Your Ref: 2016/93147  
Our Ref: S016845

24th November 2016

**444 Bradford Road, Batley - Outline application for erection of residential development**

Appendix D: - Drainage Strategy Drawing

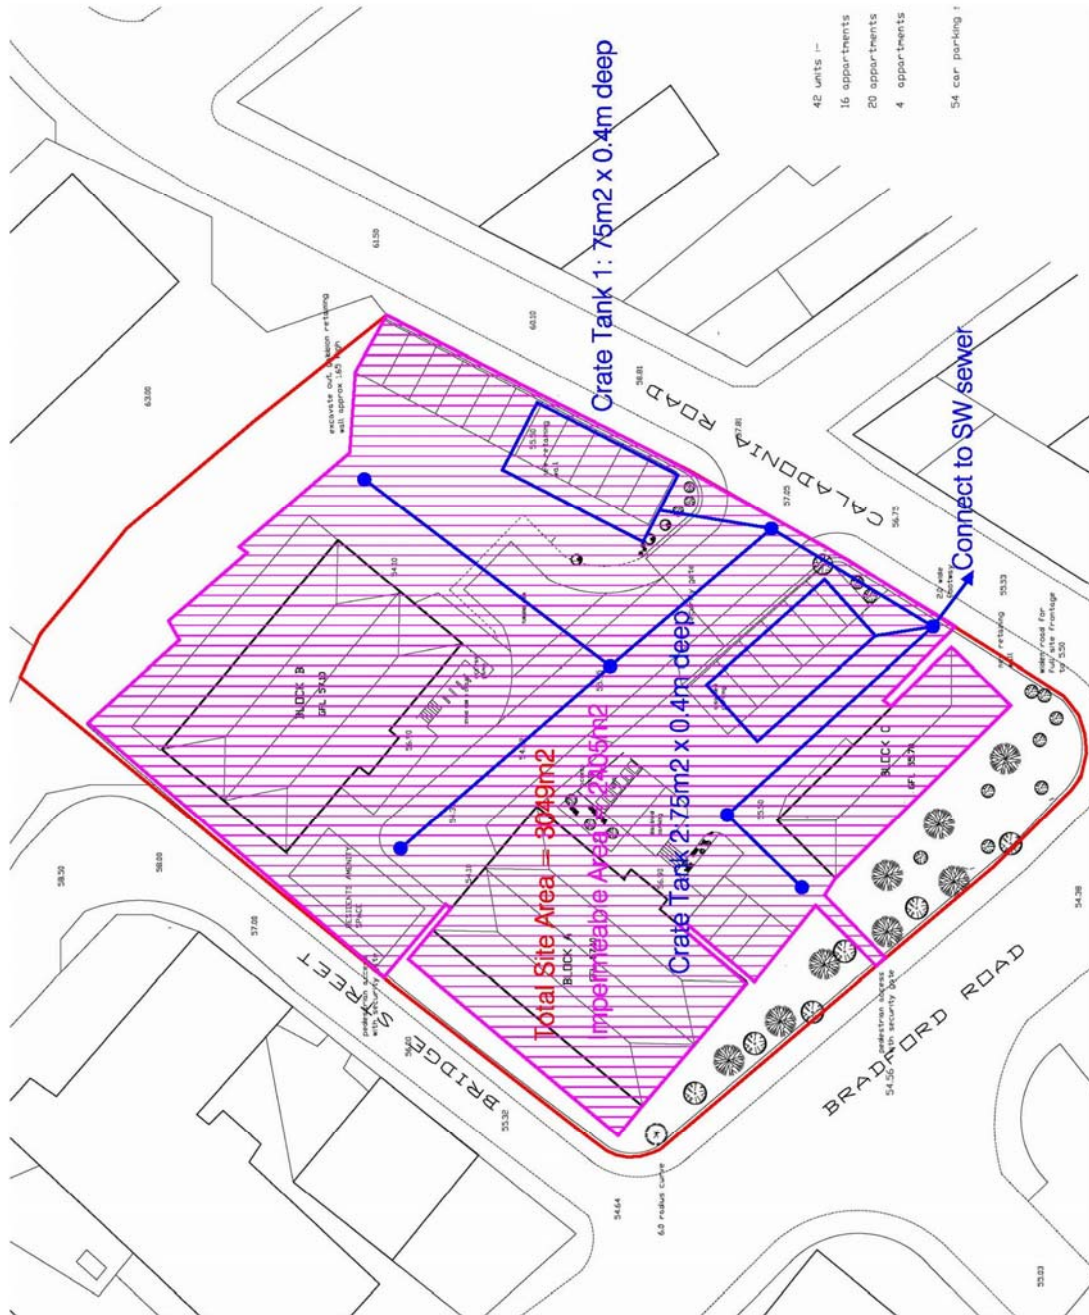
The Flood Risk Assessment (prepared by EWE Associates Ltd - Report Final Rev 0 dated May 2010) should also consider surface water disposal to a culverted watercourse which is located to the south of the site.

**SURFACE WATER** - Sustainable development requires appropriate surface water disposal. Yorkshire Water promote the surface water disposal hierarchy. The developer must provide evidence to demonstrate that surface water disposal via infiltration or watercourse are not reasonably practical before even considering disposal to a public sewer.

**No development shall take place until details of the proposed means of disposal of surface water drainage, including details of any balancing works and off-site works, have been submitted to and approved by the local planning authority. Furthermore, unless otherwise approved in writing by the local planning authority, there shall be no piped discharge of surface water from the development prior to the completion of the approved surface water drainage works.**
